# CITY OF ALBUQUERQUE

**Re: Indian Ridge Townhomes  
Erosion and Sediment Control Plan  
Engineer's Stamp Date 3-24-16 (H22E078)**

Based upon the information provided in your submittal received 3-24-16 the above referenced plan is approved to be included in the SWPPP and for ESC Permit for grading and Building Permit with the condition:

ENGINEER'S SEAL    4/21/16 5/17/16  DAVID SOULE P.E. #14522	TRACT 2-A INDIAN RIDGE SUBDIVISION	DRAWN BY JDG
	GRADING AND DRAINAGE PLAN	DATE 11-16-2015
  1606 CENTRAL AVENUE SE SUITE 201 ALBUQUERQUE, NM 87106 (505) 872-0999	SHEET # DRB 03	JOB #

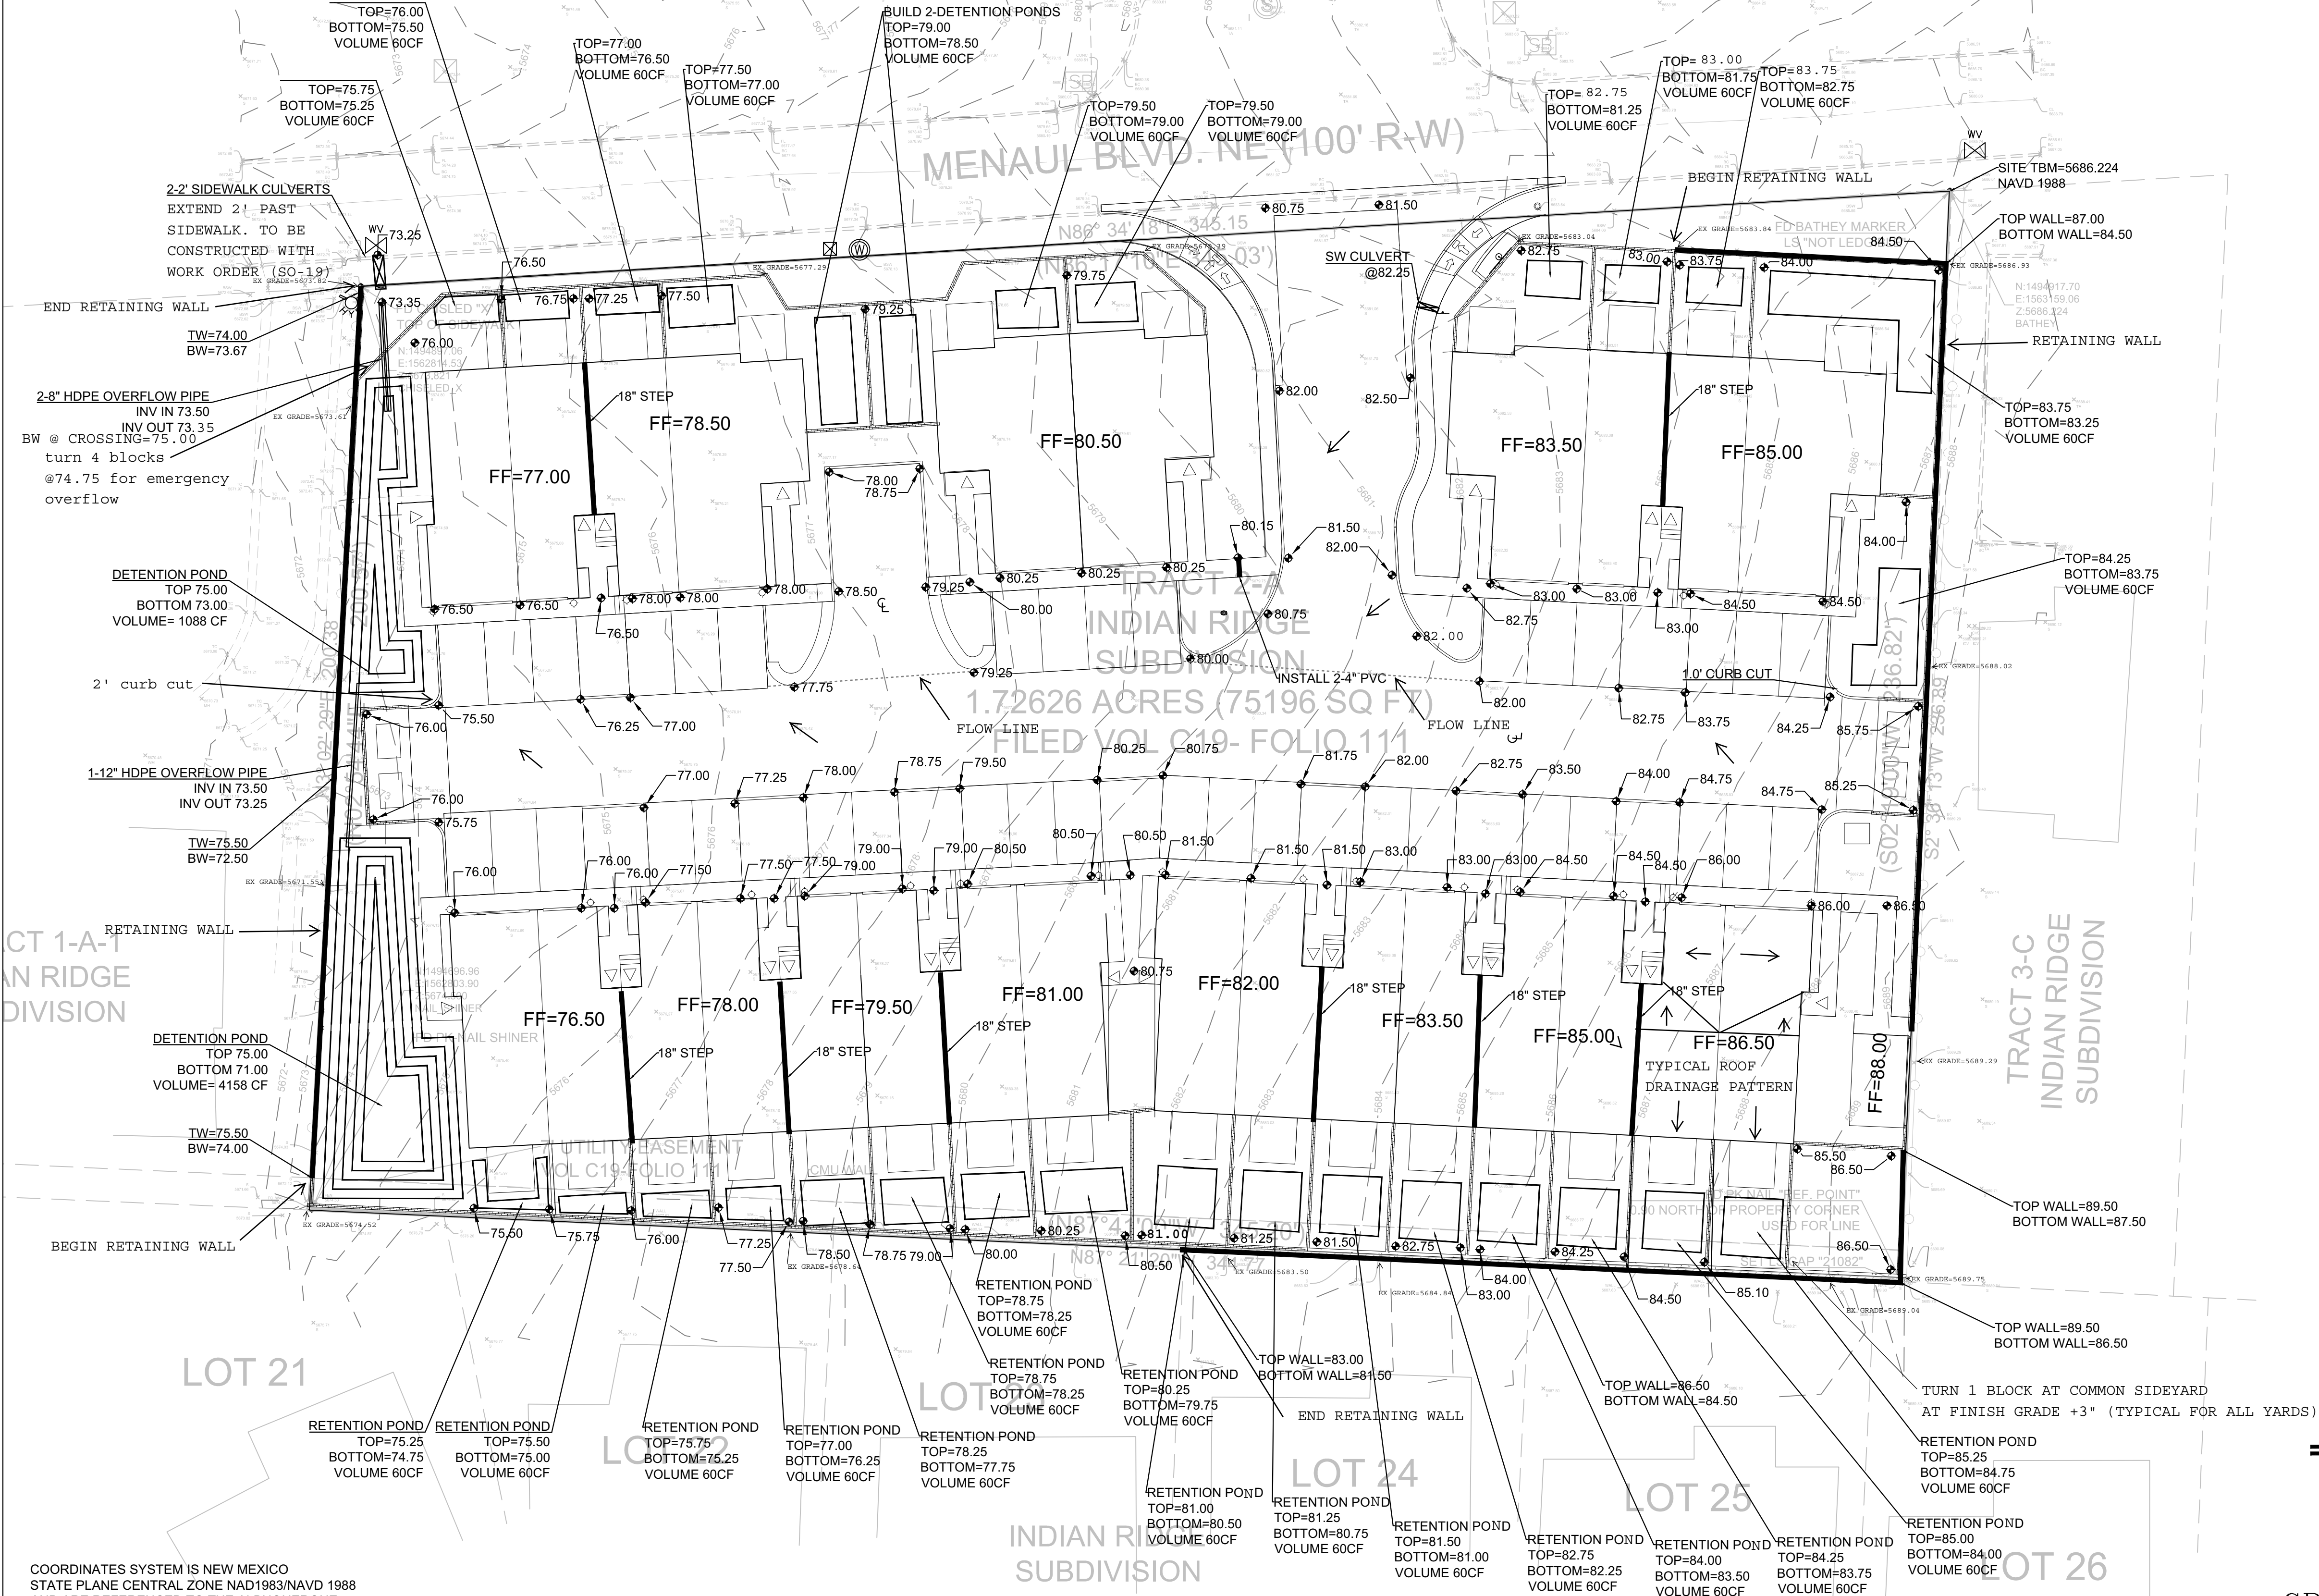
A mulch sock or alternative acceptable sediment BMP be installed along the west property line.
